**REF: 23/02399/REM****Location: Land North Of Bicester Avenue Garden Centre  
Oxford Road Bicester****18 October 2023**

PROJECT		BICESTER ARC	
TITLE			
ZONE B		SITE LAYOUT PLAN

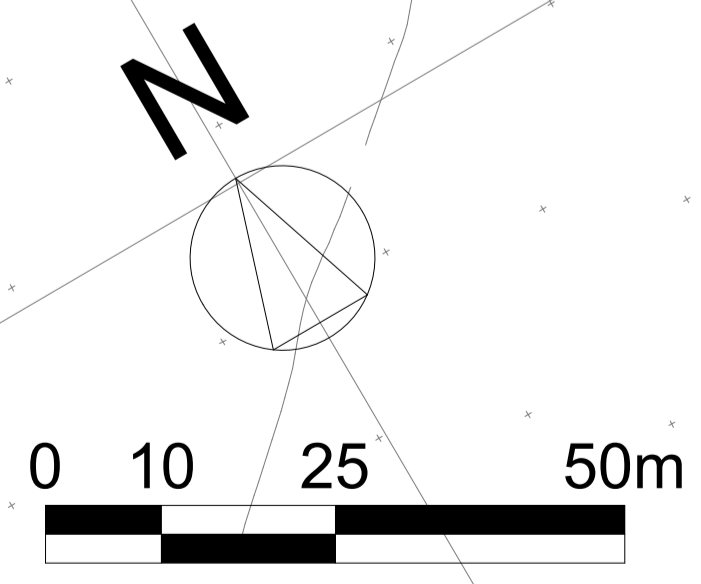
- All parking spaces should be covered by CCTV to deter crime and aid in the detection and prosecution of offenders. CCTV systems should be designed holistically with the planting and lighting scheme to ensure no areas of conflict between these different elements.

- I am unable to locate any plans for secure enclosed cycle storage serving this development. Covered stands are suitable for temporary visitor cycle storage, however they must be located close to the entrance of the main building where they are well overlooked by high levels of surveillance and passing foot traffic. I have concerns that the proposed locations of stands currently lacks sufficient surveillance to deter theft. I ask that secure enclosed/access controlled cycle storage is provided, which is designed in accordance with the guidance of Secured By Design. Plans should be submitted prior to permission being granted.

- Cycle storage facilities should be covered by CCTV and be lit.
- I am unable to locate any plans or specifications for the external enclosures for waste. Plans indicate bin storage may be easily accessible from the public realm creating vulnerability. It is important that accessible bin stores are provided with enhanced levels of security, and I ask that all doors are secured to a minimum LPS 1175 SR2. Enclosures should be fully covered by CCTV. I ask that plans for waste storage facilities are provided prior to permission being granted.
